HCI ENGINEERING

March 3, 2017

Re: Responses to Conditions of Approval – Dated November 14, 2016

Project: HCI 15-39 Taco Bell at Heritage Marketplace

Exterior Elevations

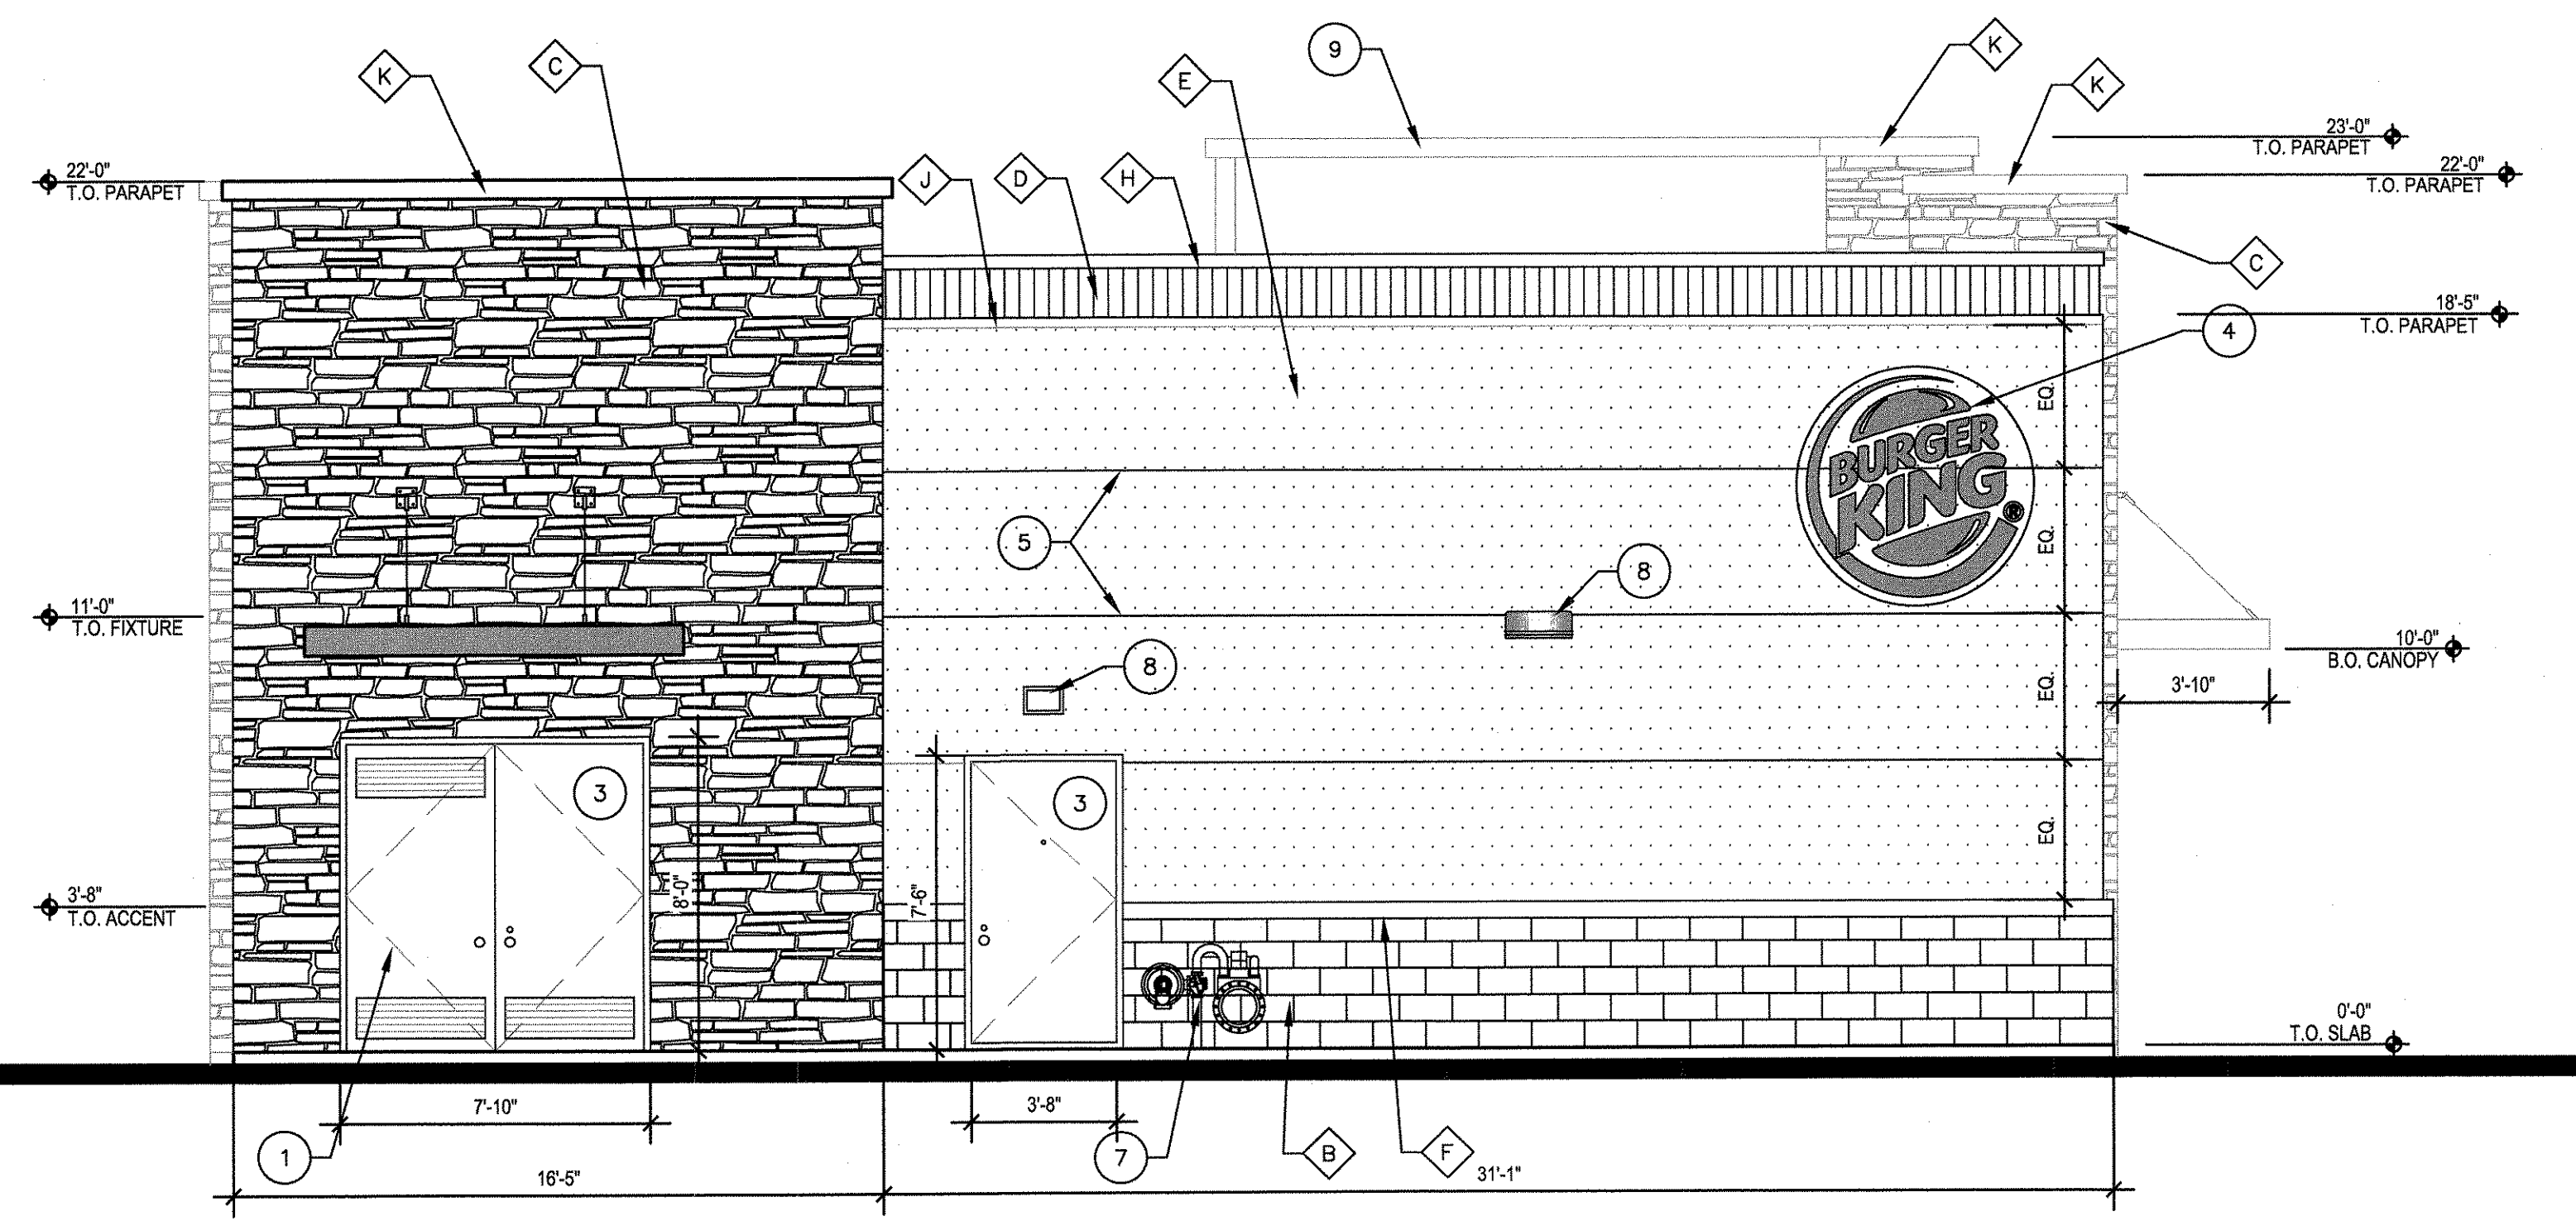
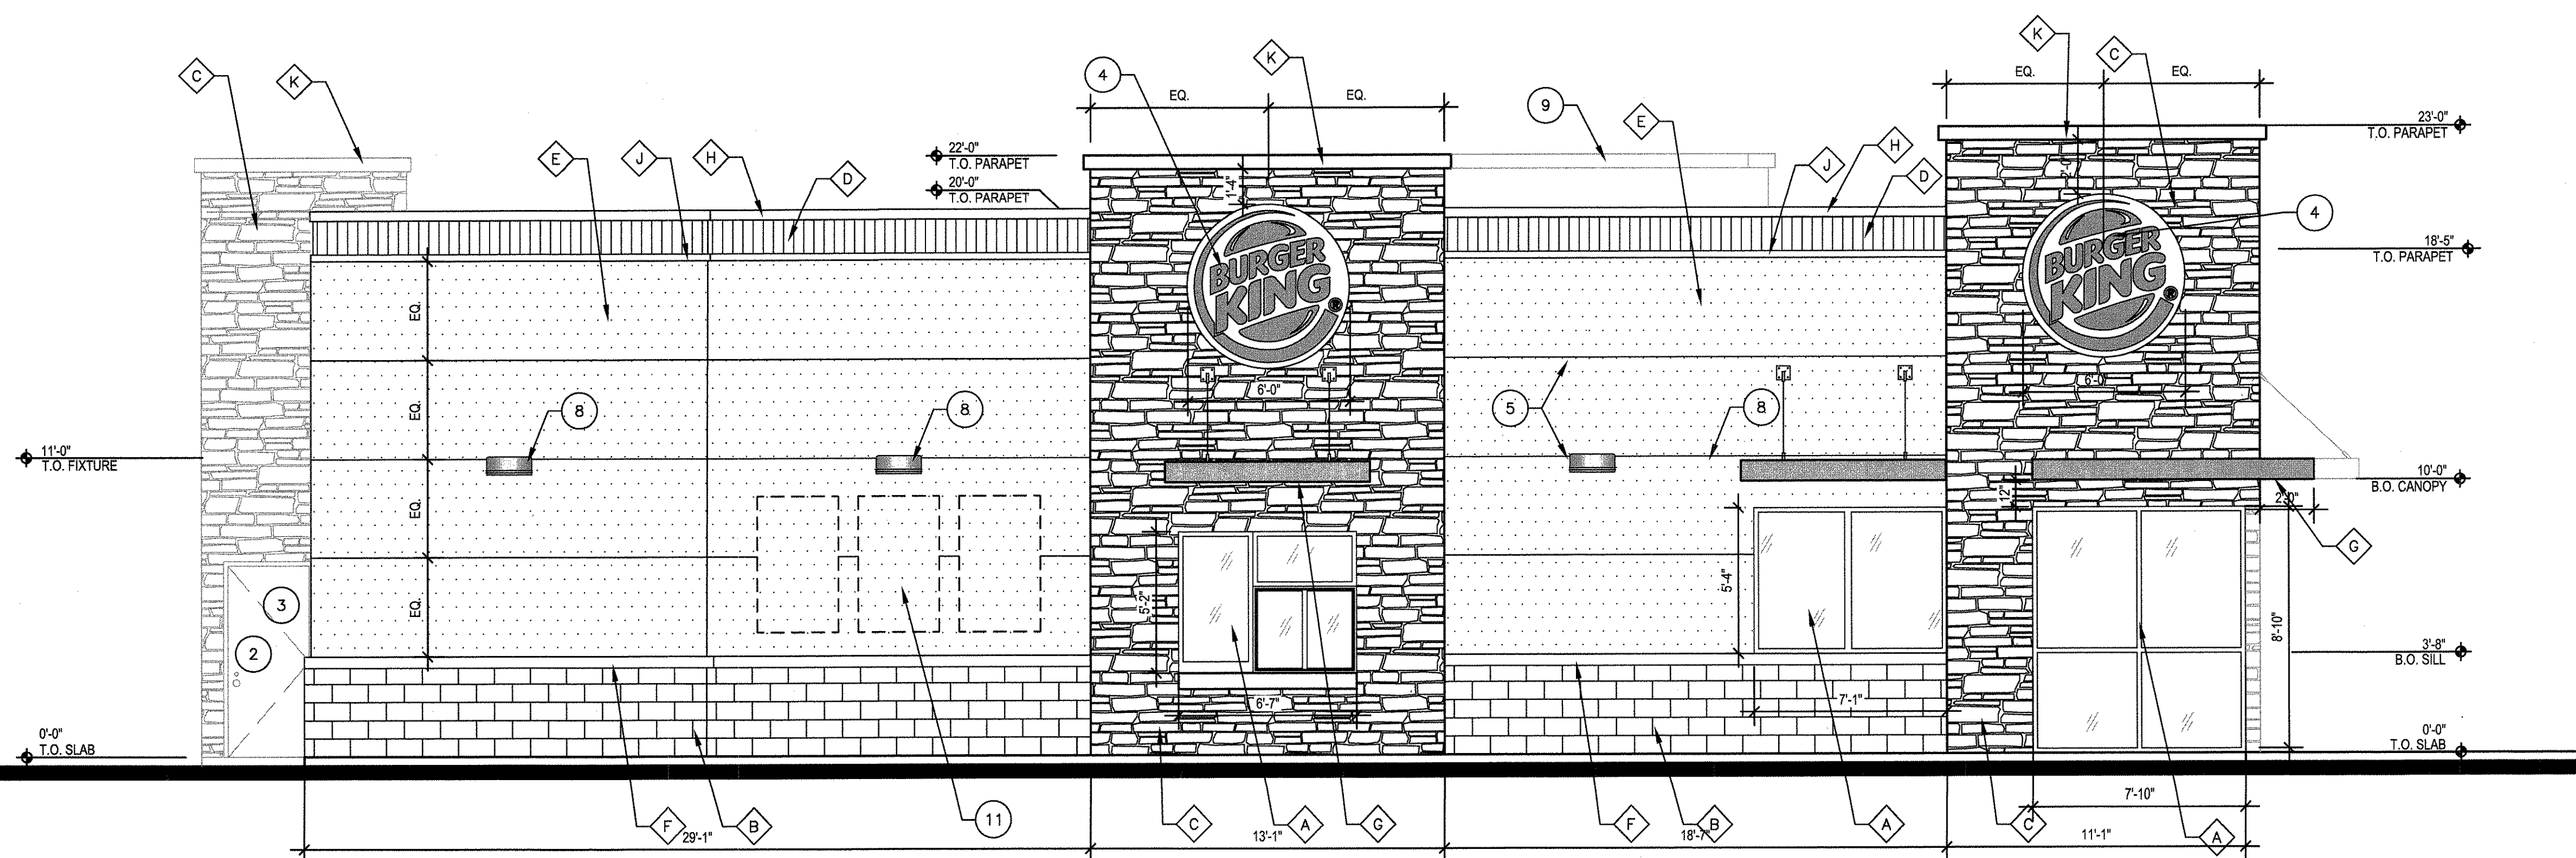
Response: The note has been added.
4. The exterior building elevations contained on Sheets A4.0 and A4.1 currently identifies the elevations according to right, left, front and rear side. Thee elevation shall be modified to read east, west, north and south elevations.

5. The signage proposed for the norther building façade on Sheet A4.1 calculate to 7.07% of the building façade and will need to be reduced to 6% or less so as not to exceed the design standards contained within the Heritage Marketplace Site Development Plan for Subdivision.

Response: The elevations have been labeled as east, west, north and south accordingly.

Response: The signage area has been modified to 6% of the building façade.
